Application by Elements Green Trent Limited: Great North Road Solar and Biodiversity Park (Application Reference: EN010162)

Submissions at Deadline 2

Appendix 1 of this letter provides an overview of the documents submitted by the Applicant at this Deadline. Table 1 comprises the application documents for which updated versions are being submitted and summarises how and why the document has been updated.

0 20 40 80 120 160 metres

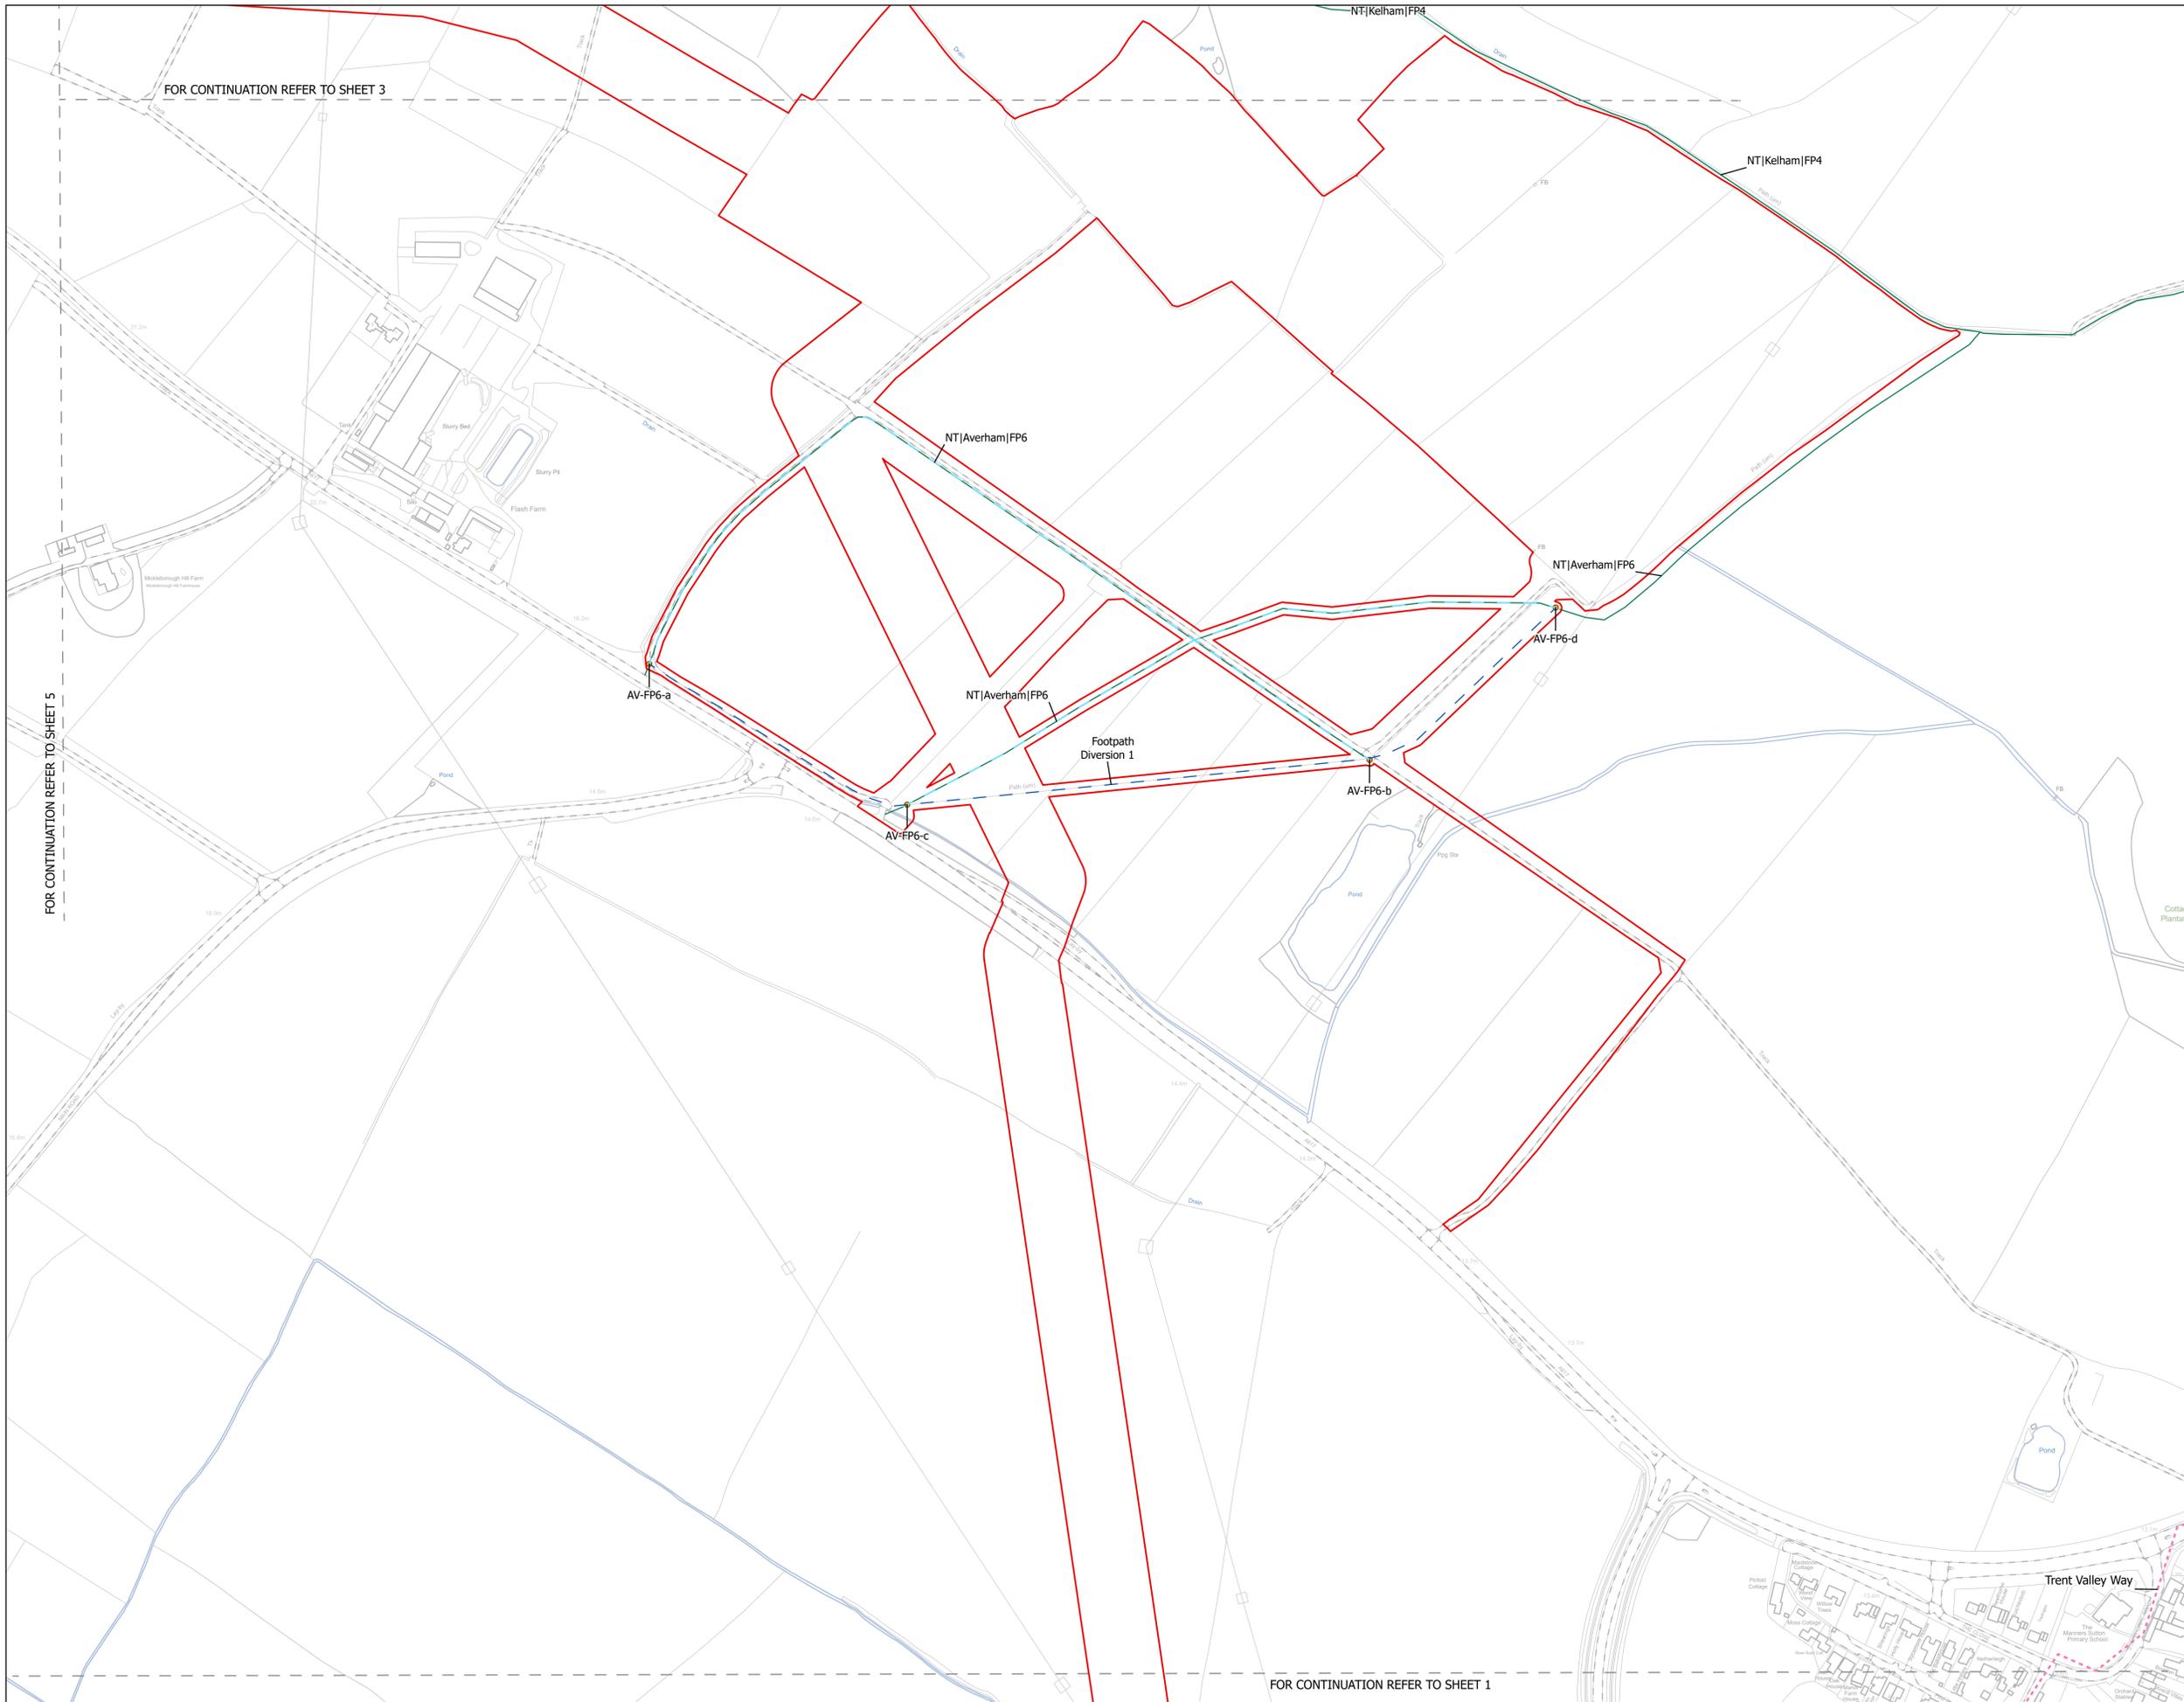
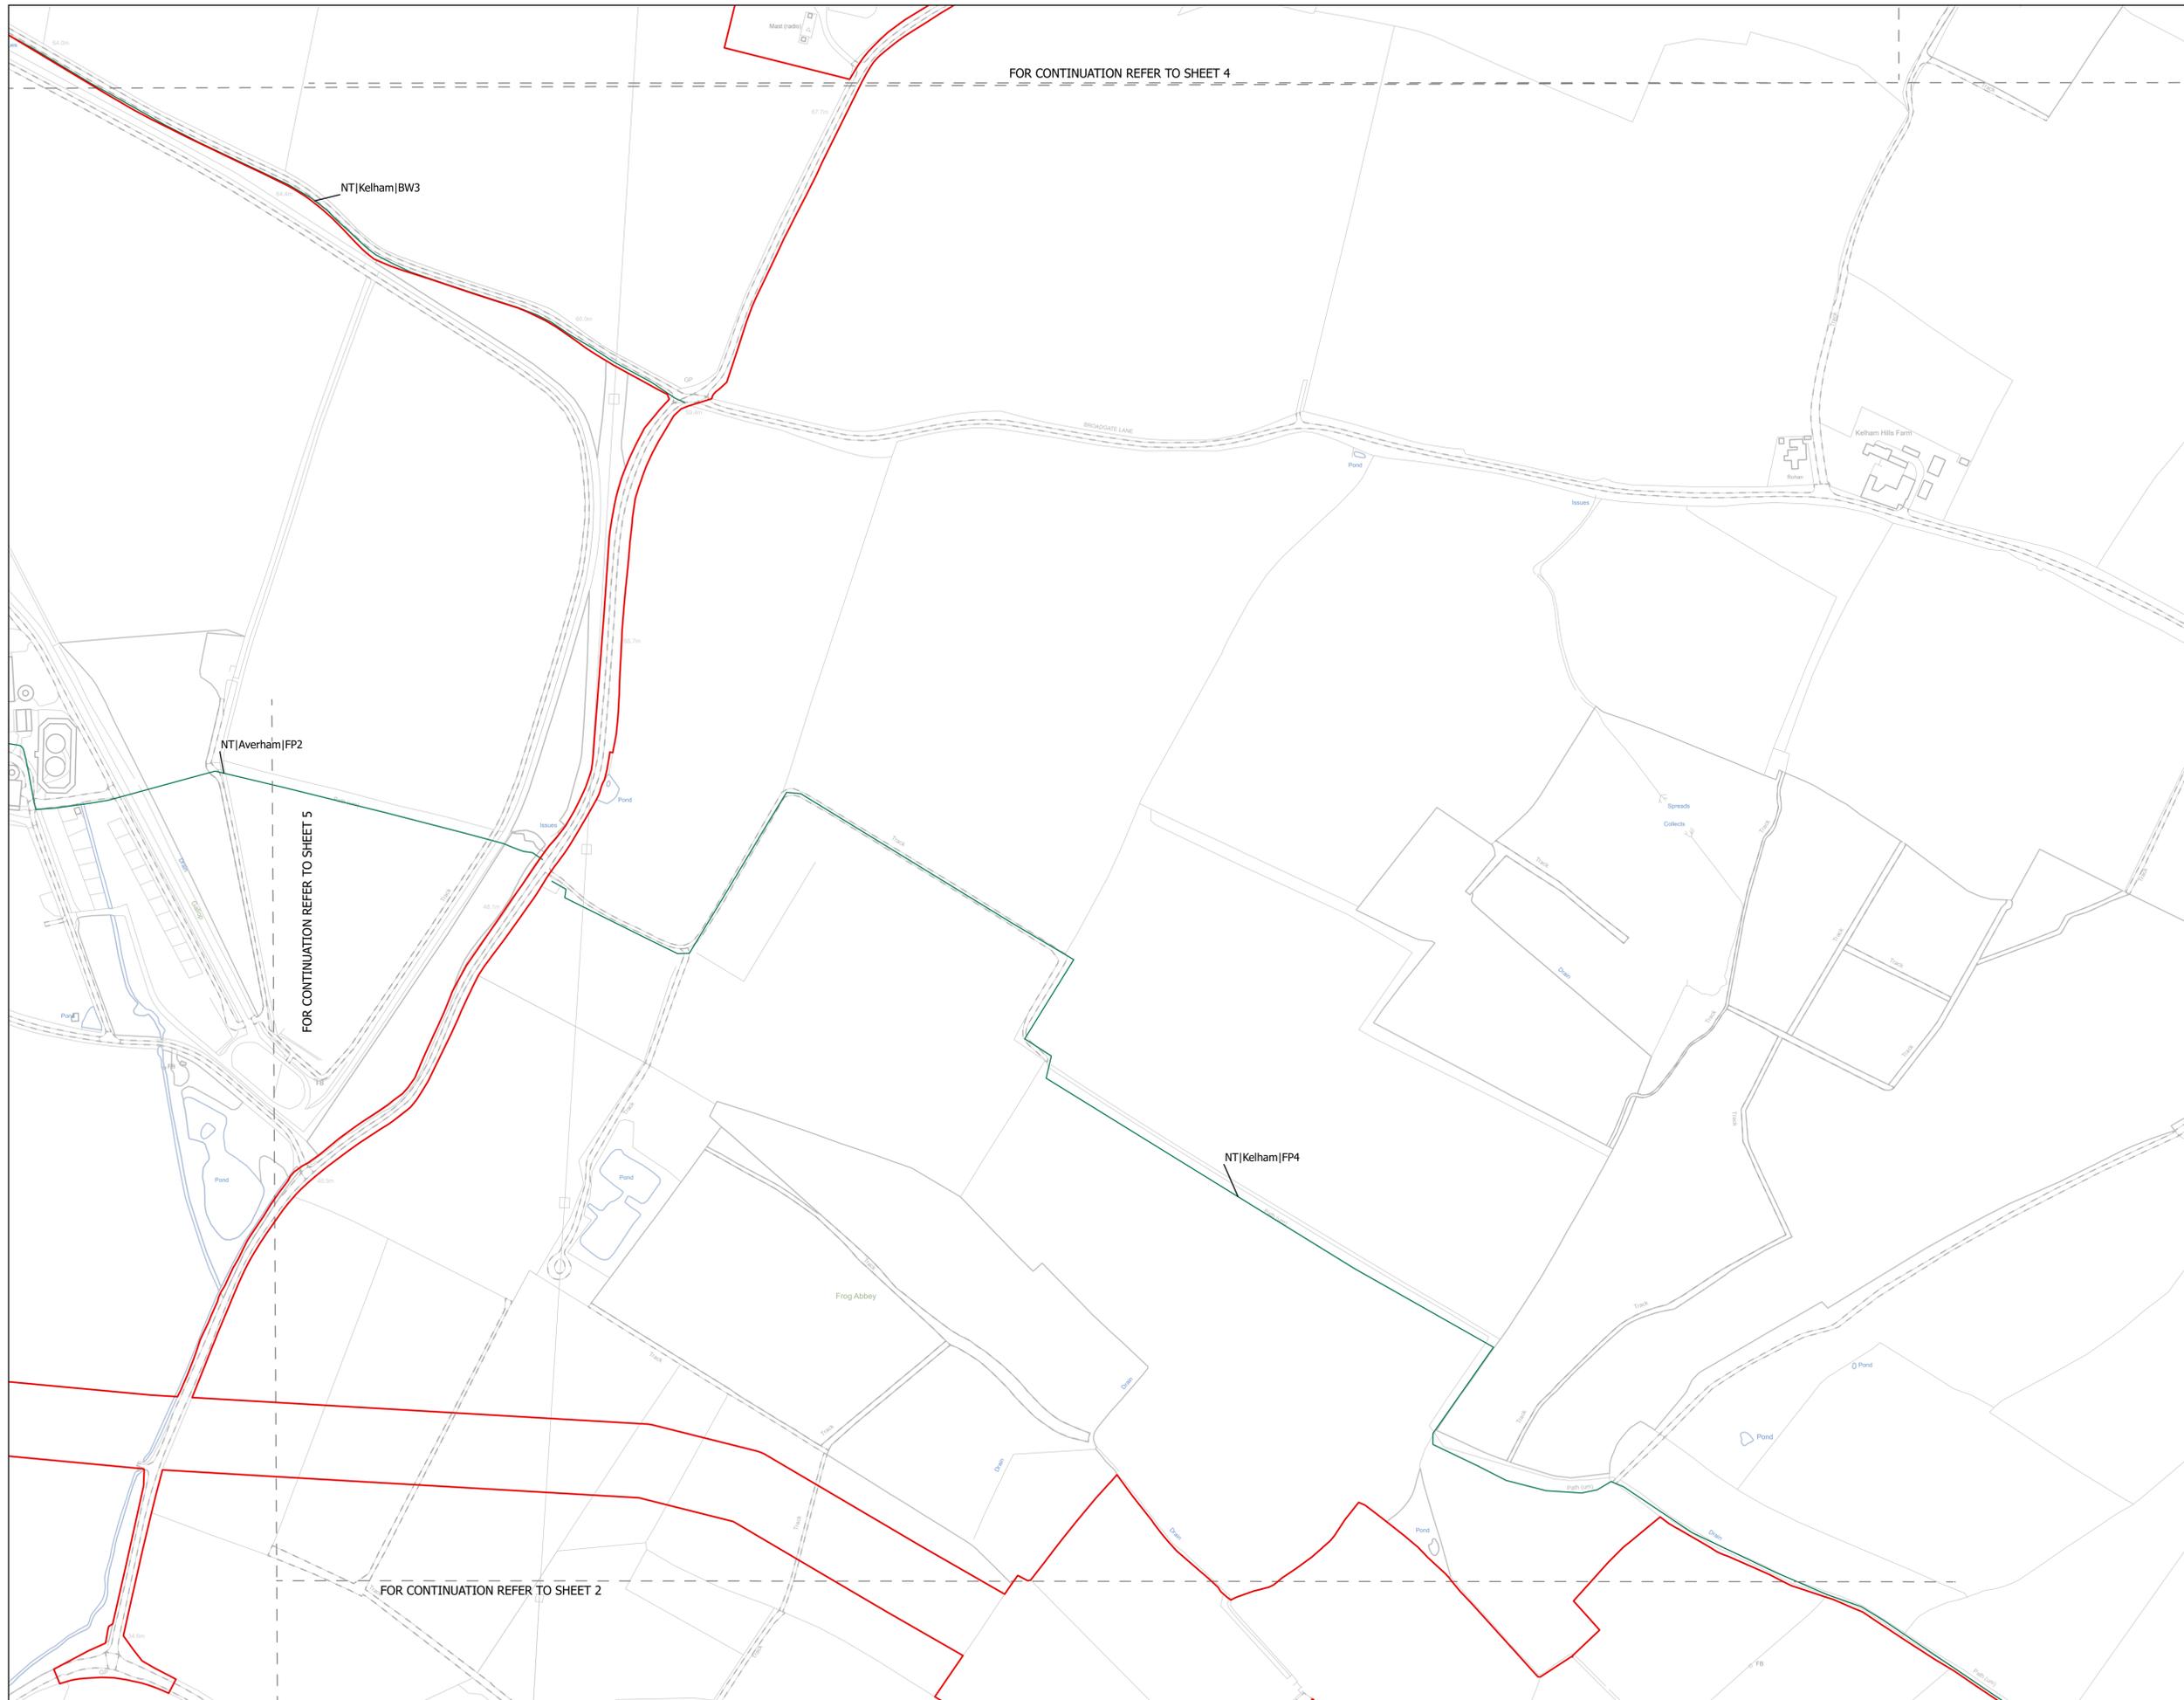
2.4A	2	Public Rights of Way Diversions and Permissive Routes Plan	Updated Figure to remove part of Permissive Bridleway along Bridleway Diversion for Construction and Decommissioning only route
